Land South of A259 New Road and East of Brook Lane, Angmering, West Sussex – Planning Application A/11/17/OUT

02 August 2017

Our Ref VL/SPRUST(BROOKLANE).1
Your Ref A/11/17/OUT

Land South of A259 New Road and East of Brook Lane, Angmering, West Sussex –
Planning Application A/11/17/OUT

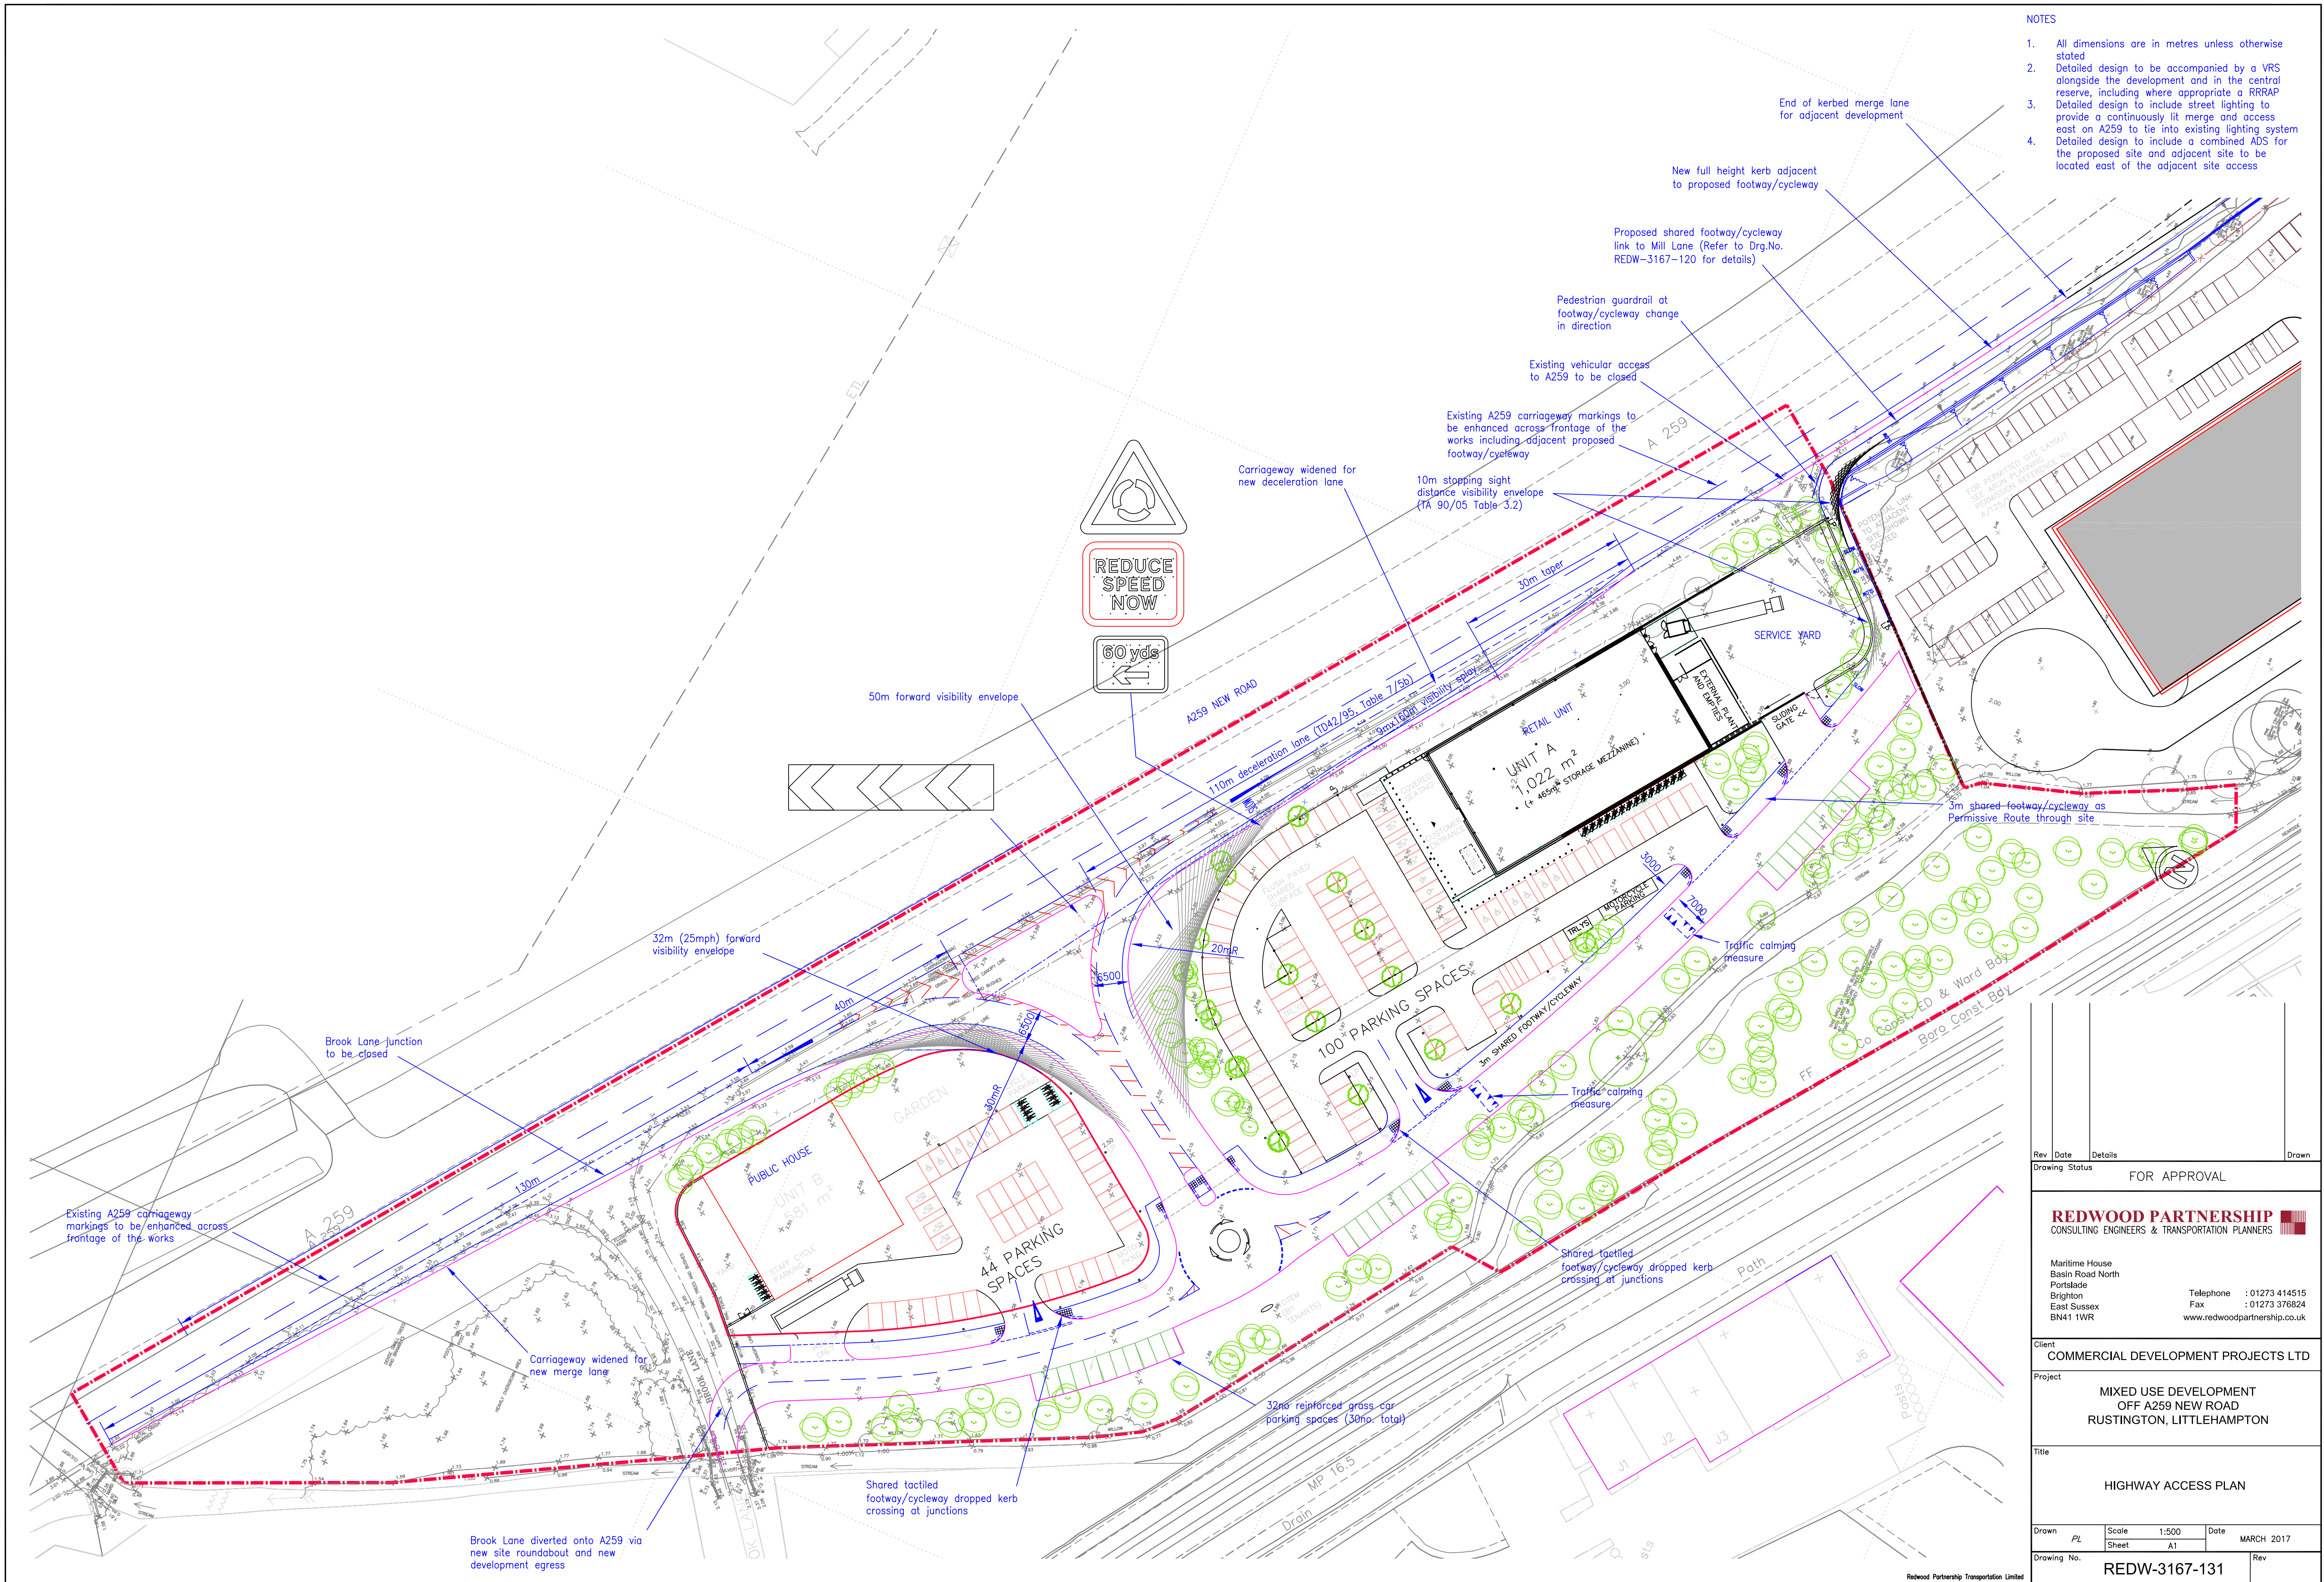
The proposed access arrangements are shown on Redwood Partnership's drawing number REDW-3167-131 A. The access arrangement relies on the closure of Brook Lane. West Sussex County Council's comments on the application, the Road Safety Audits and the Design Audit are all based on Brook Lane being closed to facilitate the new access to the east. The new access shown on Redwood Partnership's drawing would be located approximately 90m east of Brook Lane and it would be unsafe for both accesses to co-exist.

The Applicant's latest plan REDW-3167-131A shows pedestrian/cycle linkage east of the proposed site adjacent the A259, north of Manor Retail Park. However, their proposals do not reflect the as built drawings for Manor Retail Park. As shown in the attached hybrid drawing, the pedestrian and cyclist paths would not link up. This will add to the number of people driving between the two retail parks and likely cause further highway issues, especially when considered alongside the sub-standard highway design.

The footway/cycleway within Manor Retail Park falls entirely within the privately owned land of the retail park and not on highway land. Therefore, the cycle lane shown on REDW-3167-131A, should be designed to provide the minimum width specified by West Sussex County Council, and should form part of the applicant's proposed development.

In addition, the planning application drawings should reflect the as built Manor Retail Park layout in order that vehicular, pedestrian and cyclist linkage between the sites can be provided.
